2024/1097**Applicant:** Mr & Mrs Travis**Address:** 14 St Helens Close, Thurnscoe, Rotherham, S63 ORD**Description:** Single storey side and rear extension to single storey detached dwelling

Drawing Title
Proposed Plan Views

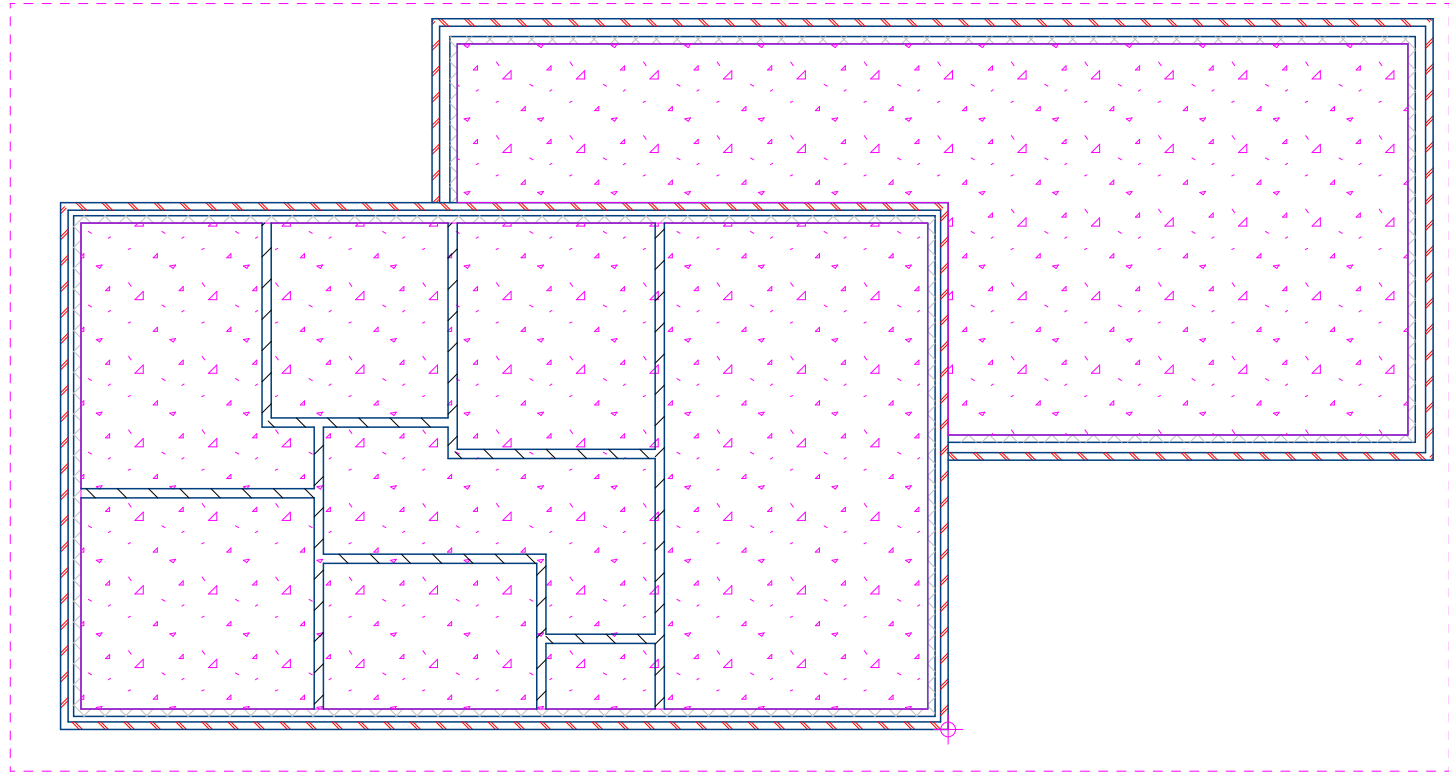
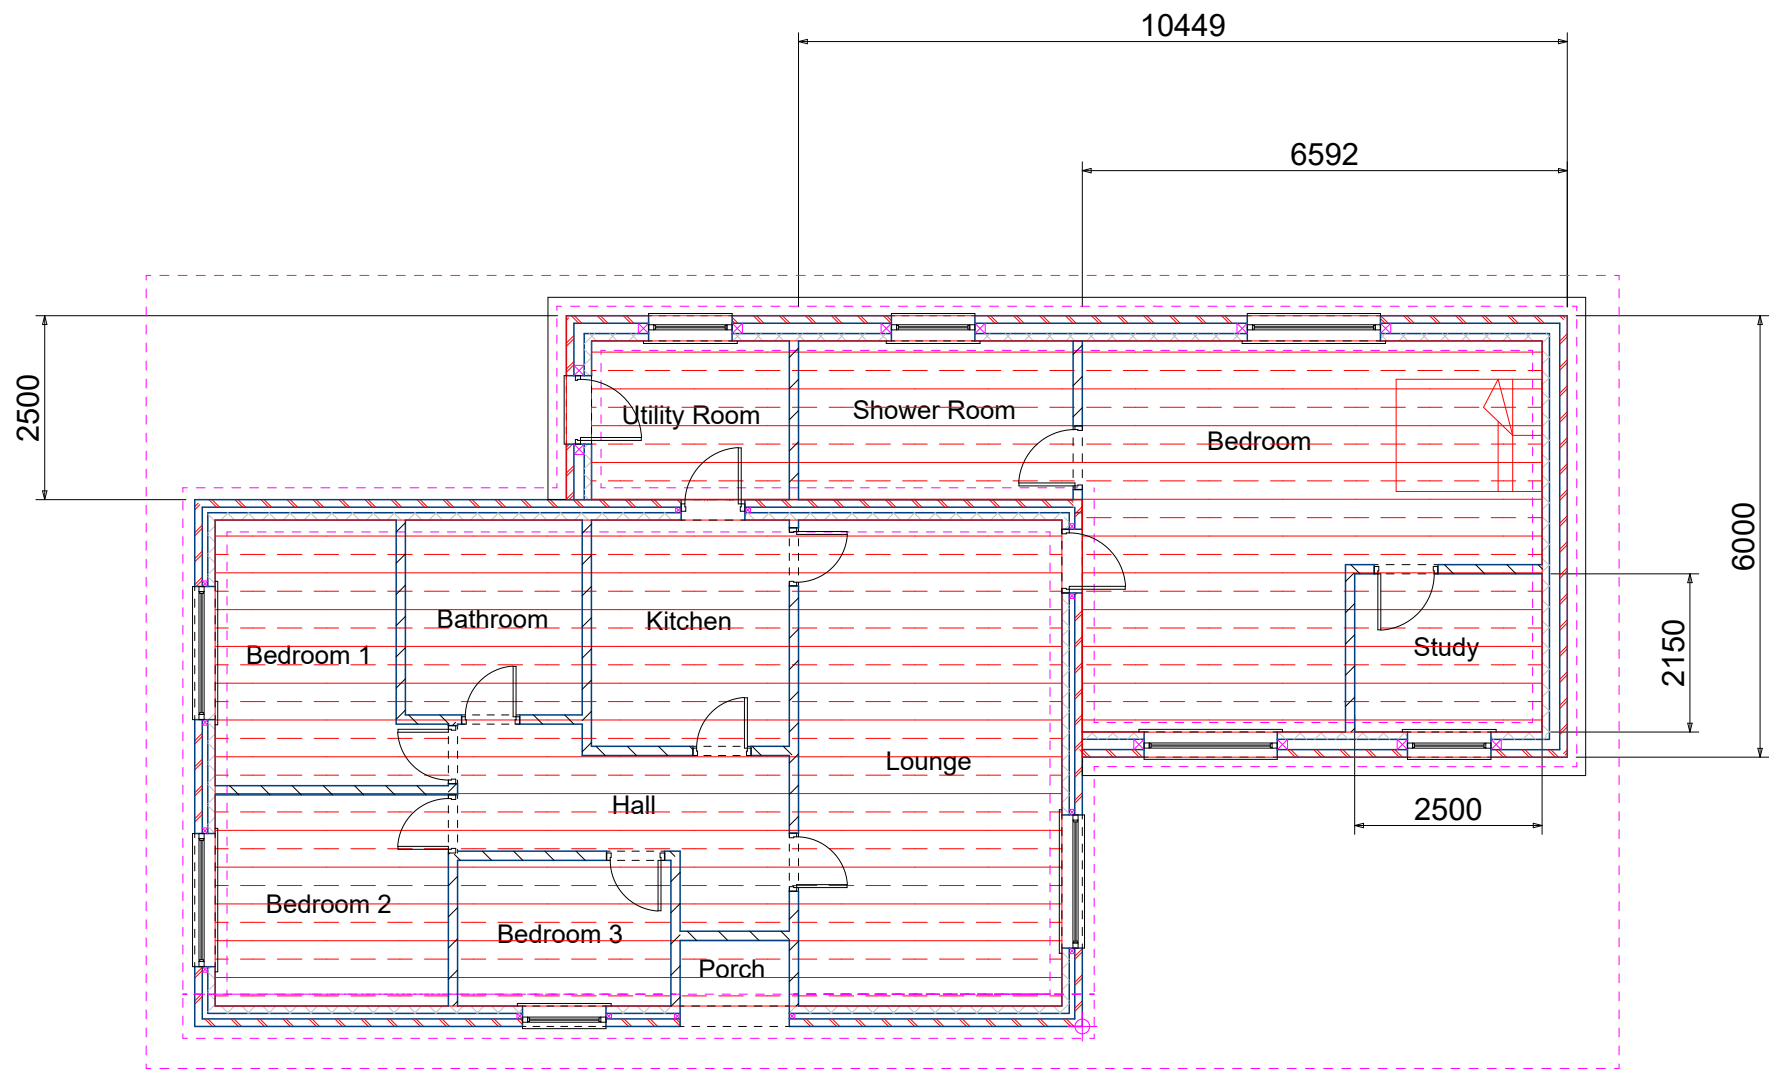
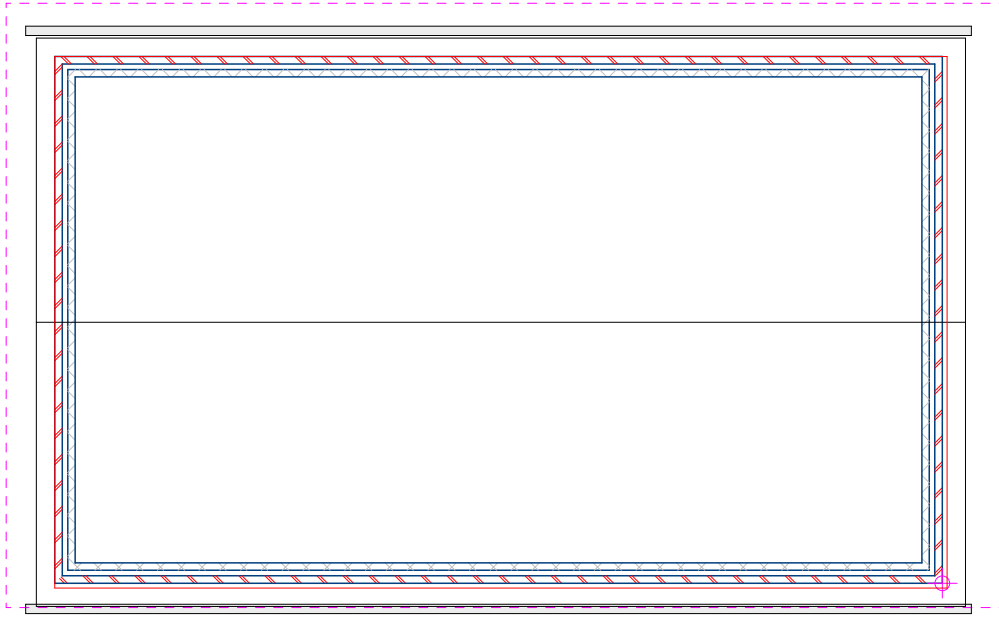
The proposal has been amended from what was described as single storey side and rear extension, into an actual single storey side and rear extension. Whilst the principal entrance door is not located, like the whole row of bungalows, on what is essentially the front elevation, this would not make the front elevation a side elevation as originally described. The proposal is now aligned to the original description with a proposal for a single storey side elevation (opposite elevation to the location of the front door), which continues beyond the rear elevation into a partial wraparound extension. The proposal features a flat roof design but is proposed to be constructed of matching brickwork

The proposal would not impact on the residential amenity of neighbouring dwellings due to its location, and the existing location of the bungalow. The bulk of the proposal is on a side elevation, described on the plans as a rear elevation, and set back from what is essentially the front elevation. The proposal would be close to the dwellings boundary which is adjacent to a small stream/drain which separates the dwelling, along with some vegetation from a large open field regarded as recreational green space but more akin to agricultural land and if it appears to be kept in a natural, broadly unkempt state.

The rear aspect of the proposal would have no or a negligible effect on the amenity of the neighbouring dwelling of No.16 or to any dwelling to the rear. Although unfinished, the land directly behind the garden is to feature a turning space and bin storage for a nearby development of five bungalows. Additionally, five replacement trees, to replace former trees lost are proposed for this area including three near the boundary with the application dwelling.
